Grittleton Parish Council

Grittleton Parish Council (Ref: FF8E77EA5) Response to The Examining Authority's Second Written Questions (ExQ2)

Title:
Figure 13-5: Abnormal Load Routes: Solar PV Sites

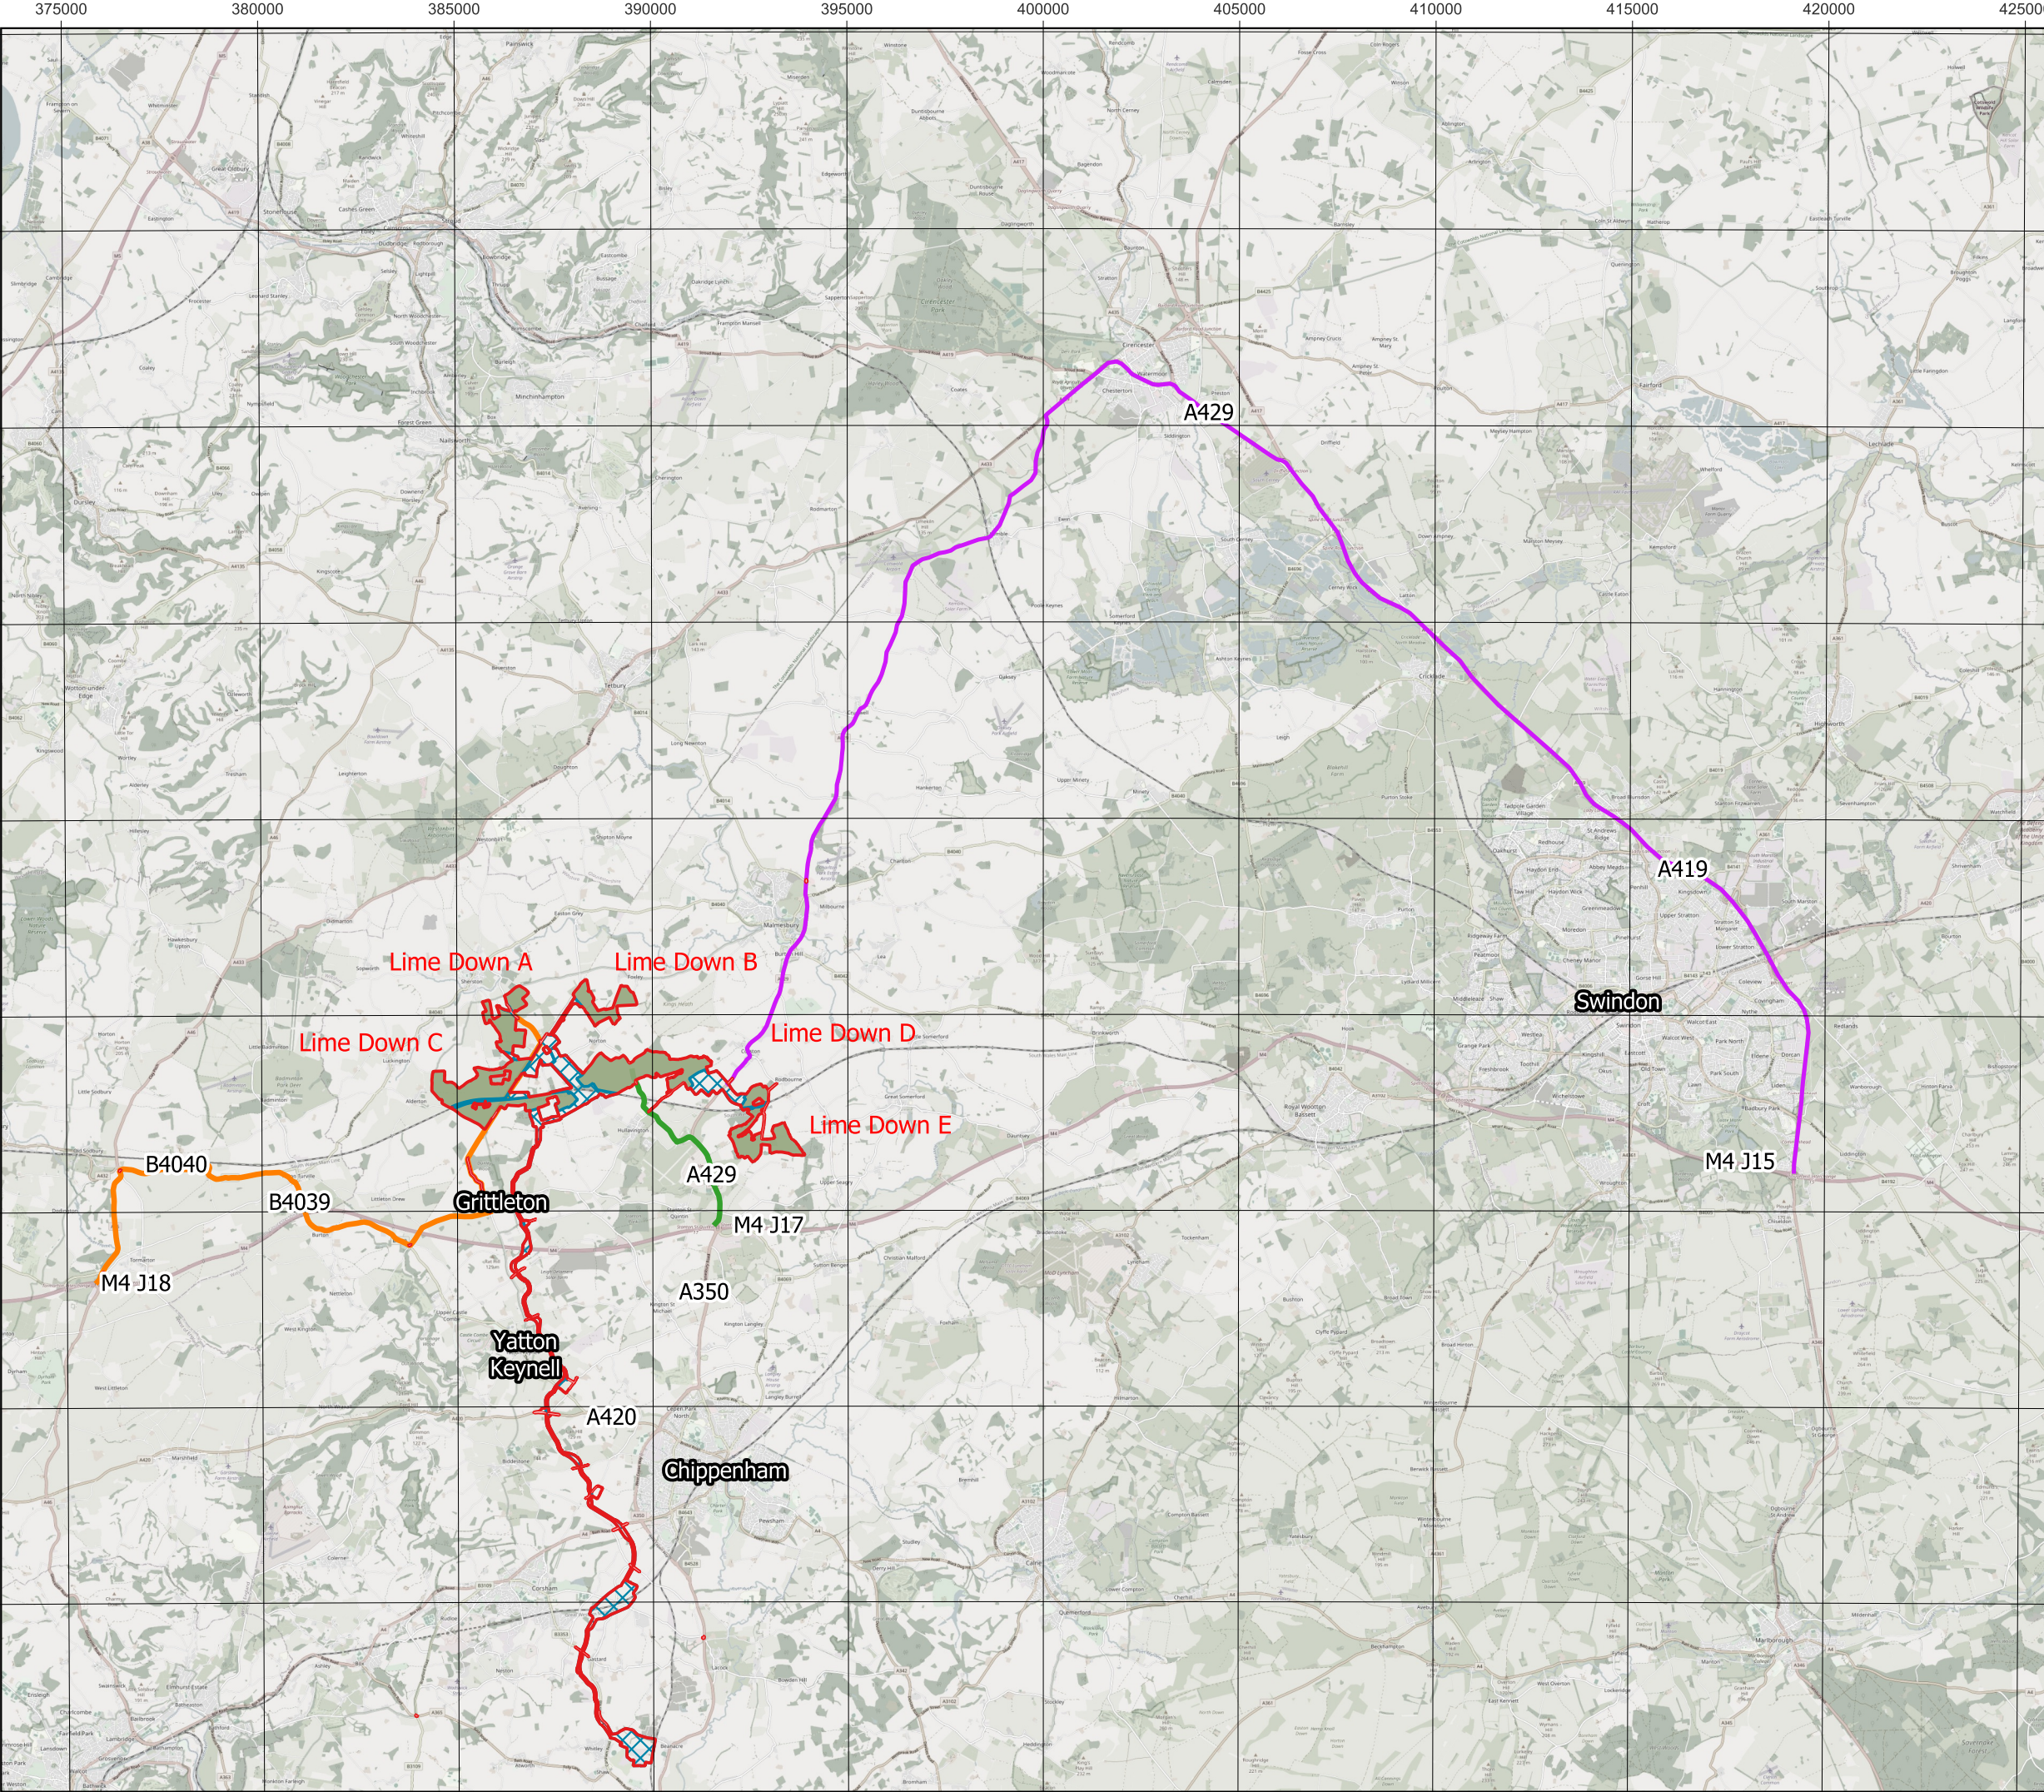
GPC note that Abnormal Loads (AIL) will be subject to separate movement controls, but seek clarification of the access and parking arrangements that would be in place at The Salutation Inn during such movements. The Salutation Inn is reliant upon the on street parking in front of the property to maintain a viable business and any restriction, even temporary would have a significant impact.

GPC seek assurance that the proposed "temporary" removal of the STOP sign at the crossroads would only be for the duration of time that an AIL is in the vicinity of the crossroads, by installation of a post & socket system of mounting the sign, for the duration of the time that AIL deliveries will take place.
